Rezoning Transportation Analysis

Petition Number: 2021-092

From: Lakisha Hull, AICP, LEED AP BD+C

Date	Description
06-01-2021	First Review (KP)
08-23-2021	Second Review (KP)
10-22-2021	Third Review (KP)

SECTION E-E PEARL PARKWAY

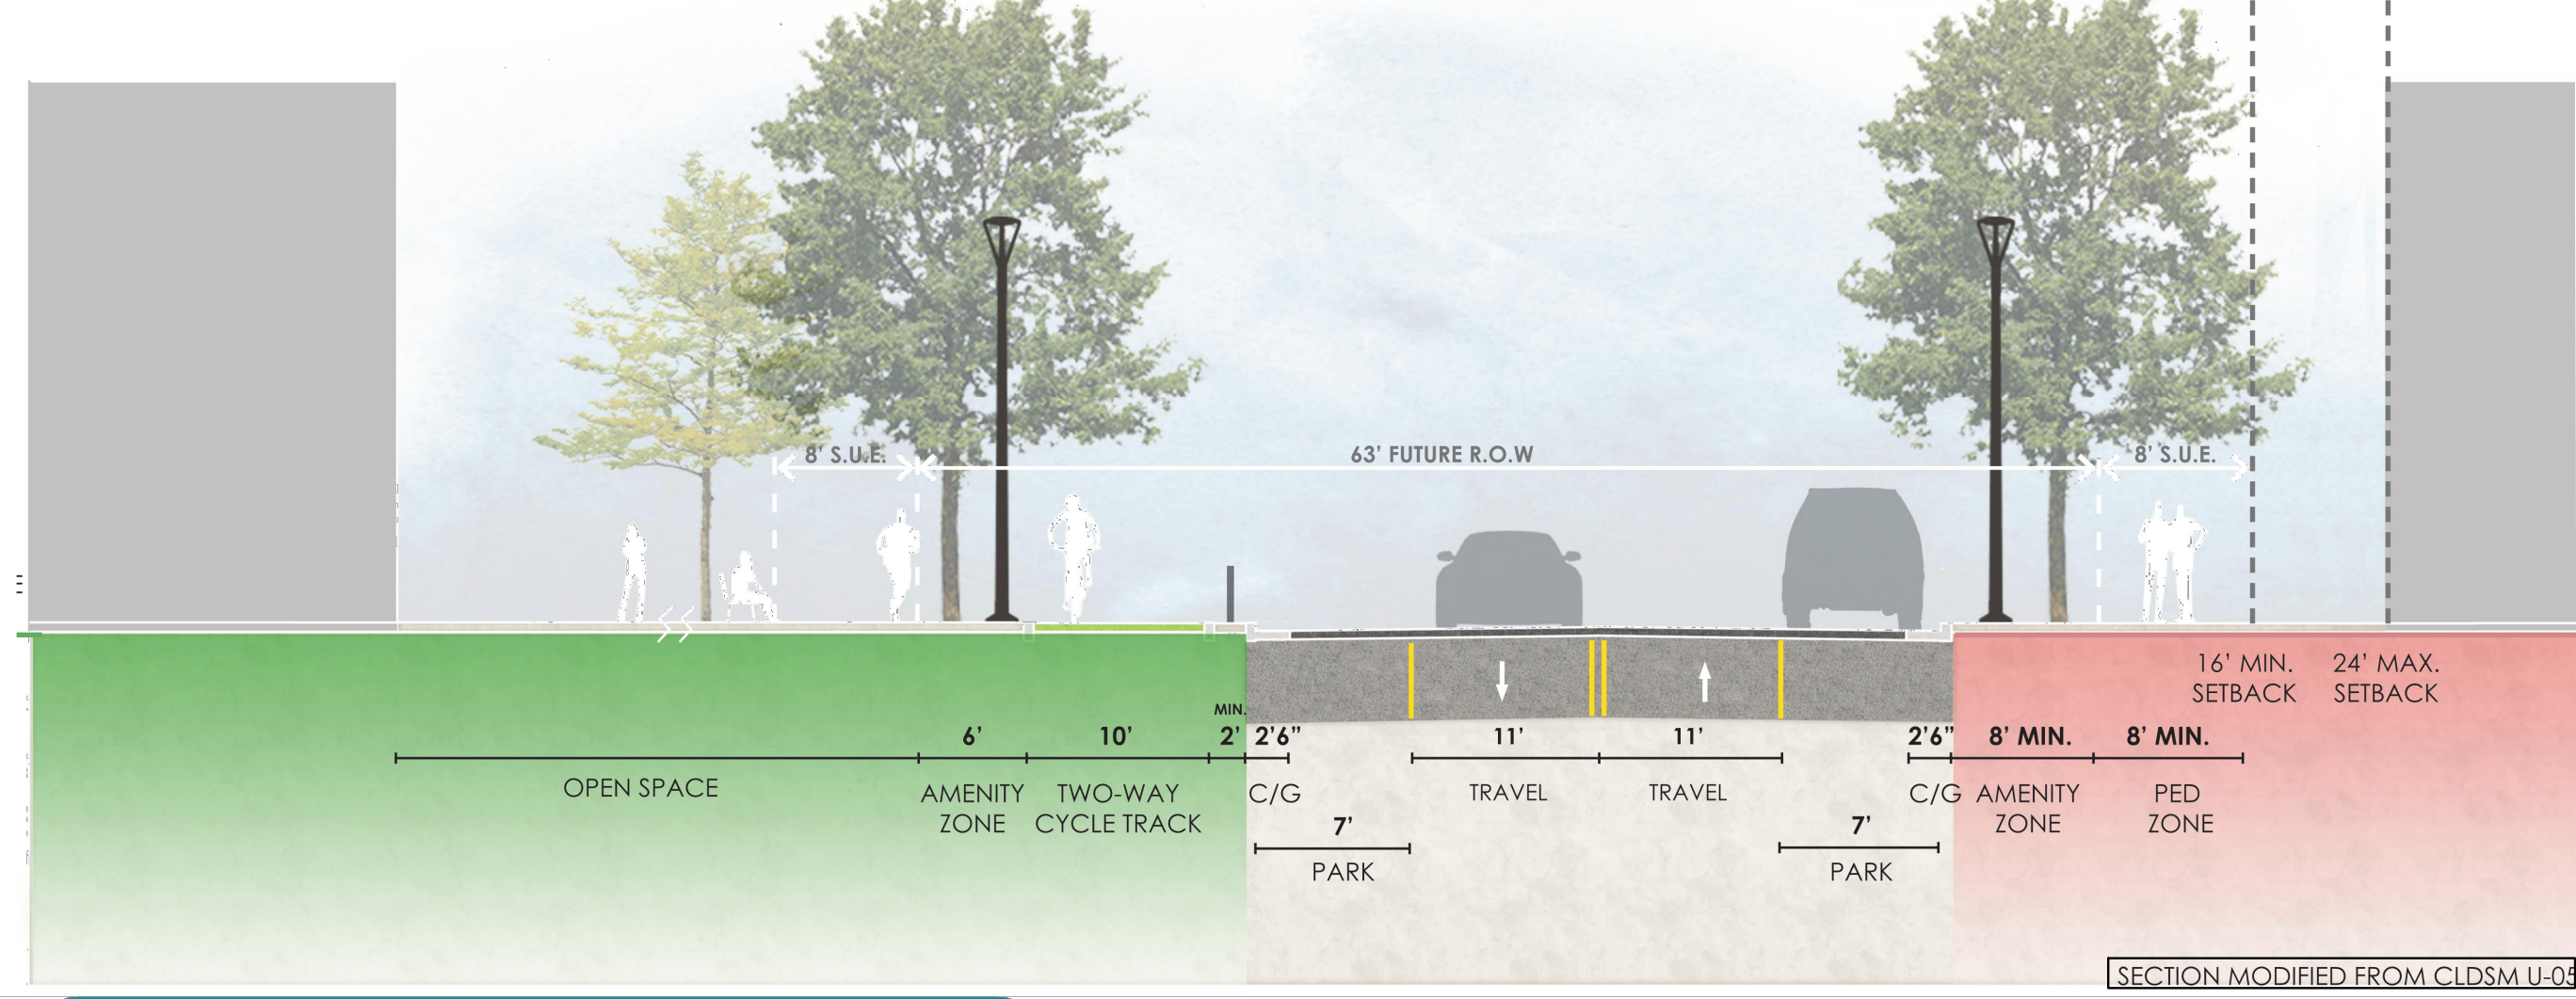
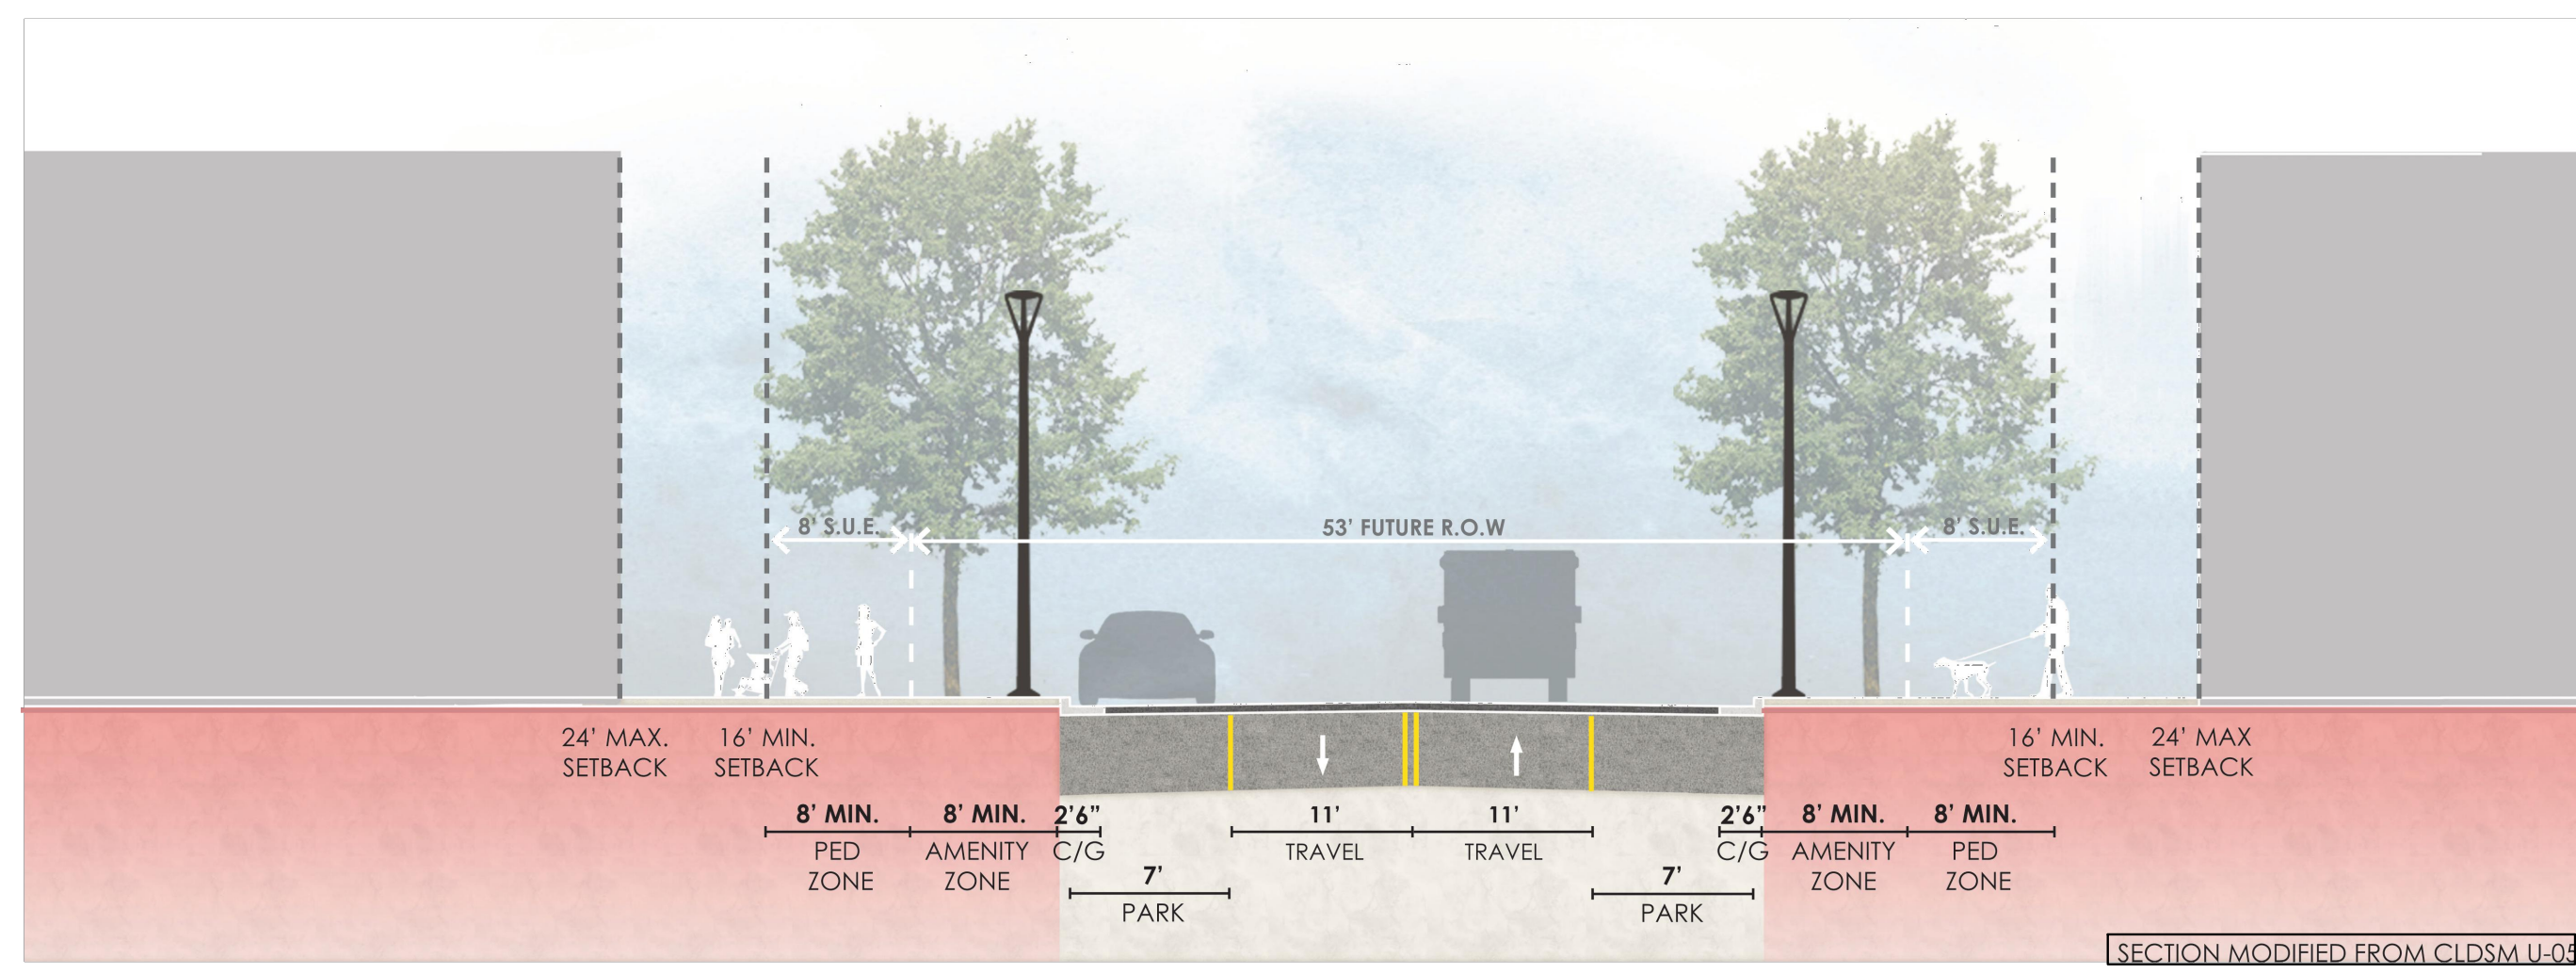
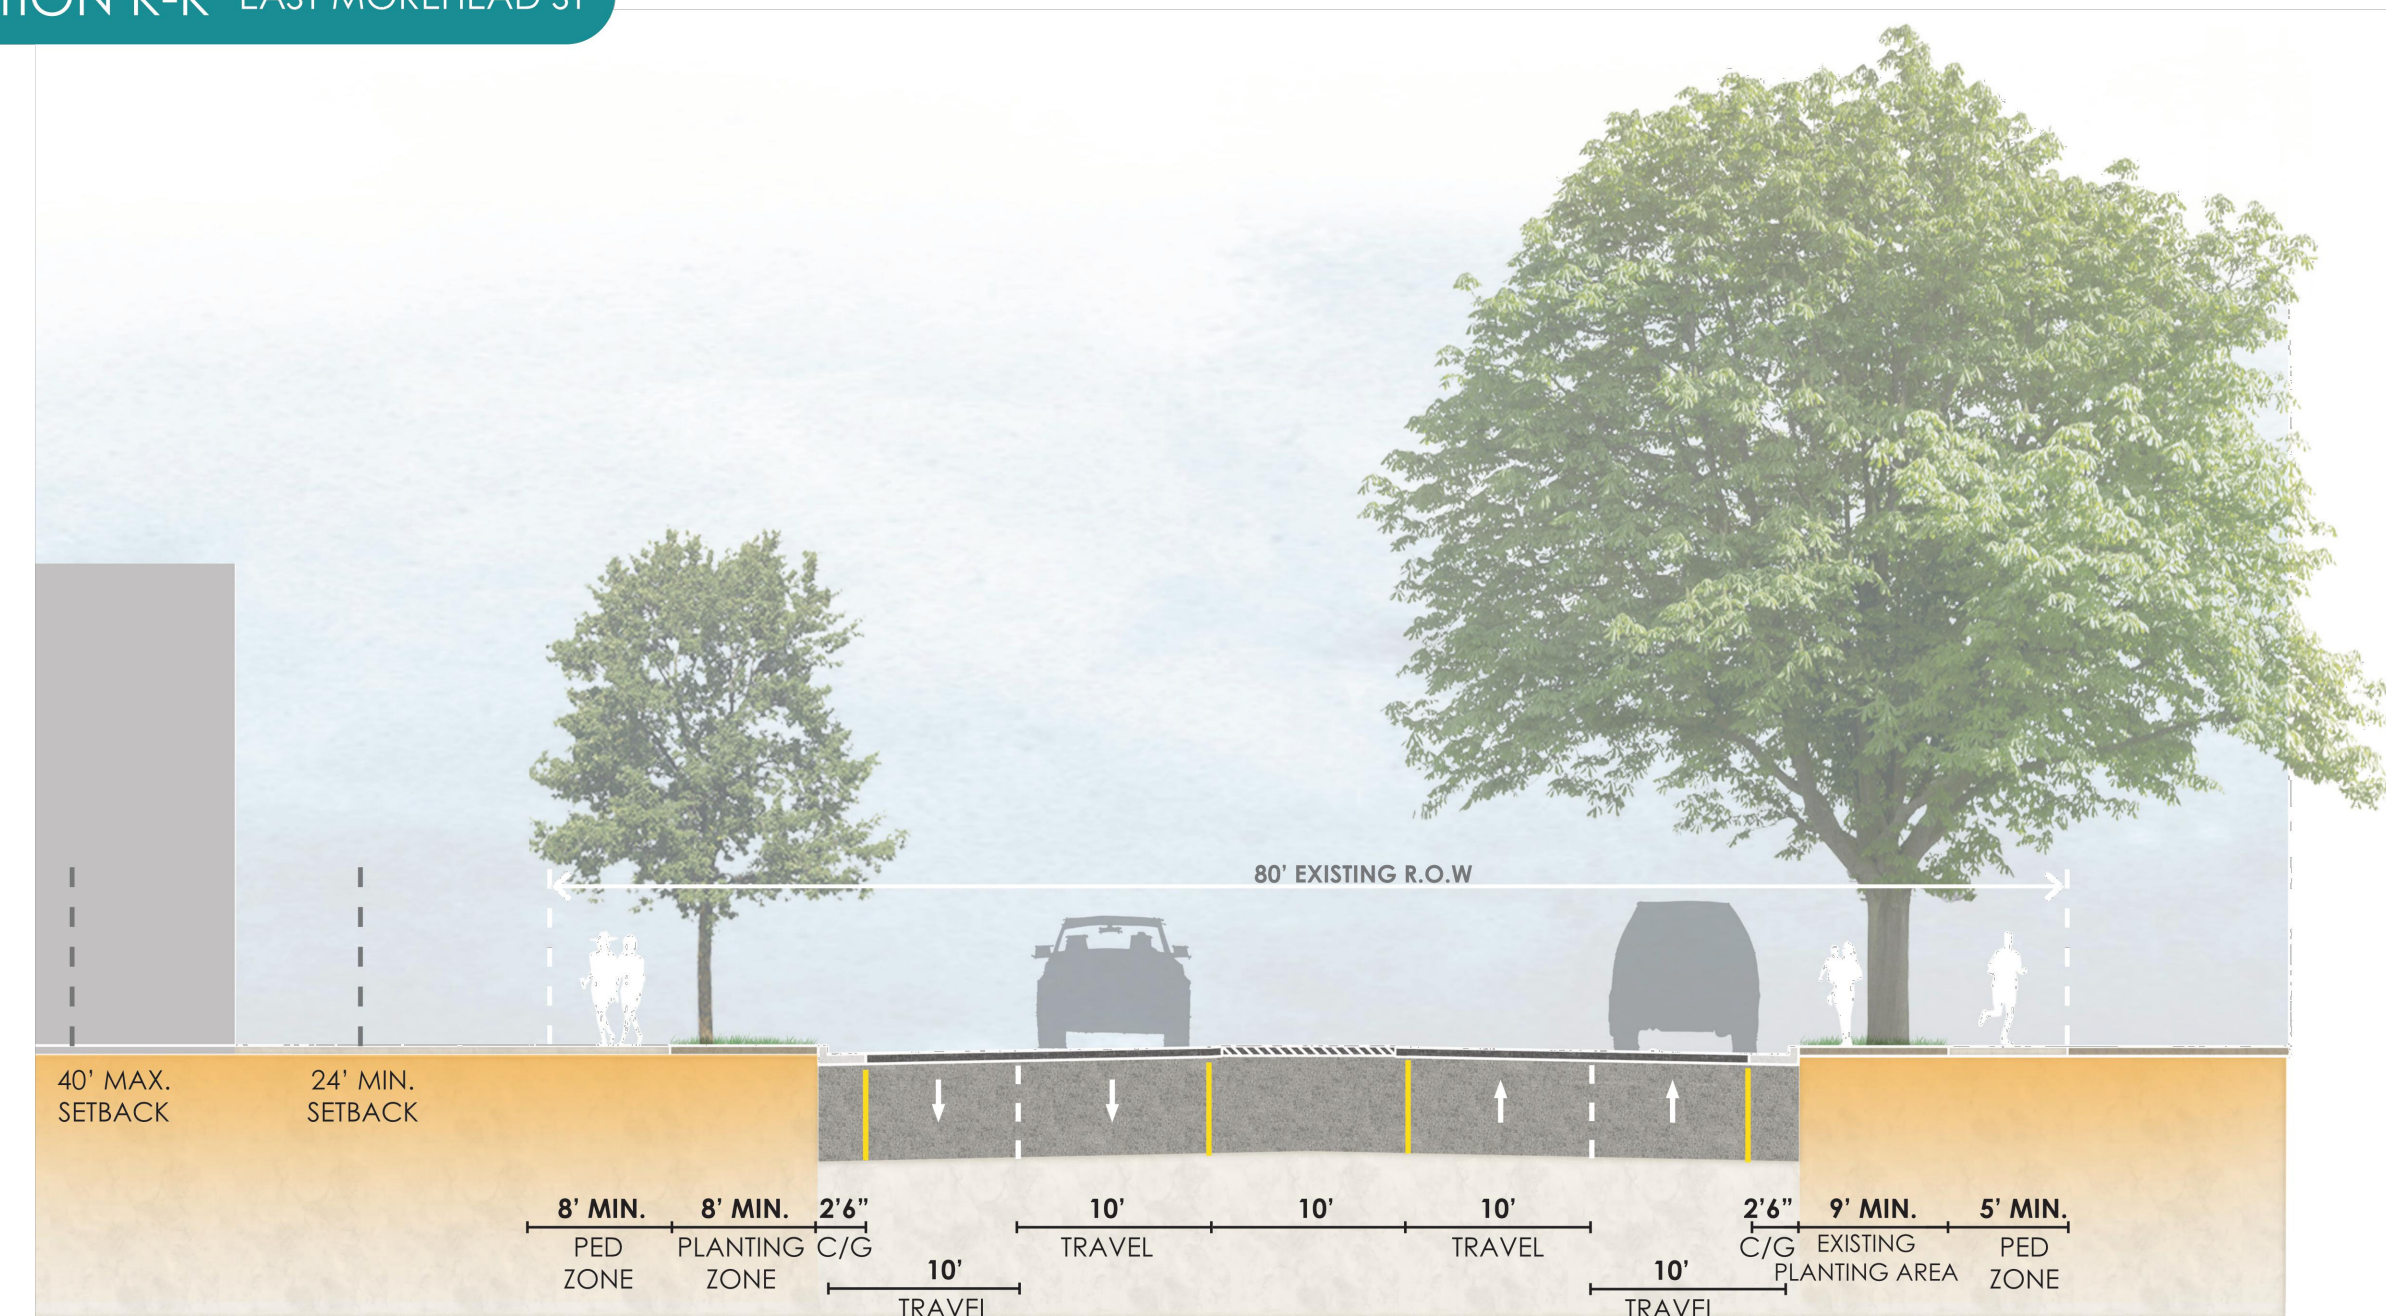
- Curb line:** ~~The proposed zoning district has a setback measured from back of the existing or proposed future curb line. Revise Sheet RZ 1.1 by adding the curb line dimensions to the cross sections provided. Please note: The following curb line dimensions proposed are conceptual and may be altered as coordination with CDOT throughout the rezoning process ensues.~~

- ~~**Morehead Street:** The location of curb and gutter will be moved and located 38-feet from the existing centerline to the back-of-curb. (Revise Site Plan Dated: 10.12.21) Update to comply with Chapter 20 sidewalk and planting strip requirements.~~

- ~~**McDowell Street:** The future location of curb and gutter is in the existing location.~~
 - ~~**Baxter Street (Section C-C)** – The location of curb and gutter will be moved and located to 21.5 feet from the existing centerline to each back-of-curb.~~

- ~~**Baxter Street (Section D-D)** – The location of curb and gutter will be moved and located to 19 feet from the existing centerline to each back-of-curb.~~

- ~~**Baxter Street Extension (Section E-E)** – The location of curb and gutter will be moved and located to 21.5 feet from the existing centerline to each back-of-curb.~~

- ~~**Proposed Public Street (Section F-F)** – The location of curb and gutter will be located 18.5 feet from the proposed centerline to each back-of-curb.~~

Update to Comment as a Result of the 08-16-2021 Site Plan:
The proposed and existing back of curb location on Morehead Street must be labeled dimensioned from the existing centerline.

- ~~**Right of way and Other Infrastructure Dimensions:** Revise Rezoning Sheet RZ 1.1 to include detailed dimensions for each infrastructure item, and the total right-of-way for the cross sections shown. Refer to the USDG Cross sections and on street parking details, located within the Charlotte Land Development Standards Manual, to determine the appropriate widths associated with each infrastructure item and the cross sections' total widths. Revise the site plan sheets by clearly labeling each public and private street section as well as each access point. Labeling each street section and access point will allow for thorough comments throughout the rezoning and permitting process. CDOT prefers the separated cycle track and sidewalk for McDowell Street (cross sections A-A and B-B). Please note: The following right of way dimensions proposed are conceptual and may be altered as coordination with CDOT throughout the rezoning process ensues.~~

- ~~**Morehead Street: (10/21/2021 Site Plan) - 56-feet of right-of-way dedication measured from the existing road centerline.**~~
 - ~~**McDowell Street:** 110 feet of total right-of-way dedication, 55 feet measured from the existing road centerline to each right of way line.~~

- ~~**Baxter Street (Section C-C)** – 93 feet of total right of way dedication, 46.5 feet measured from the existing road centerline to each right of way line.~~

- ~~**Baxter Street (Section D-D)** – 86 feet of total right-of-way dedication, 43 feet measured from the existing road centerline to each right of way line.~~

- ~~**Baxter Street Extension (Section E-E)** – 93 feet of total right of way dedication, 46.5 feet measured from the existing road centerline to each right of way line.~~

- ~~**Proposed Public Street (Section F-F)** – 73 feet of total right of way dedication, 36.5 feet measured from the existing road centerline to each right of way line.~~

The proposed and existing Morehead Street right of way dedication must be labeled dimensioned from the existing centerline. **Outstanding comment (10/21/2021 Site Plan) - Revise the site plan conditional notes and legends that all new streets shall be determined as public or private during**
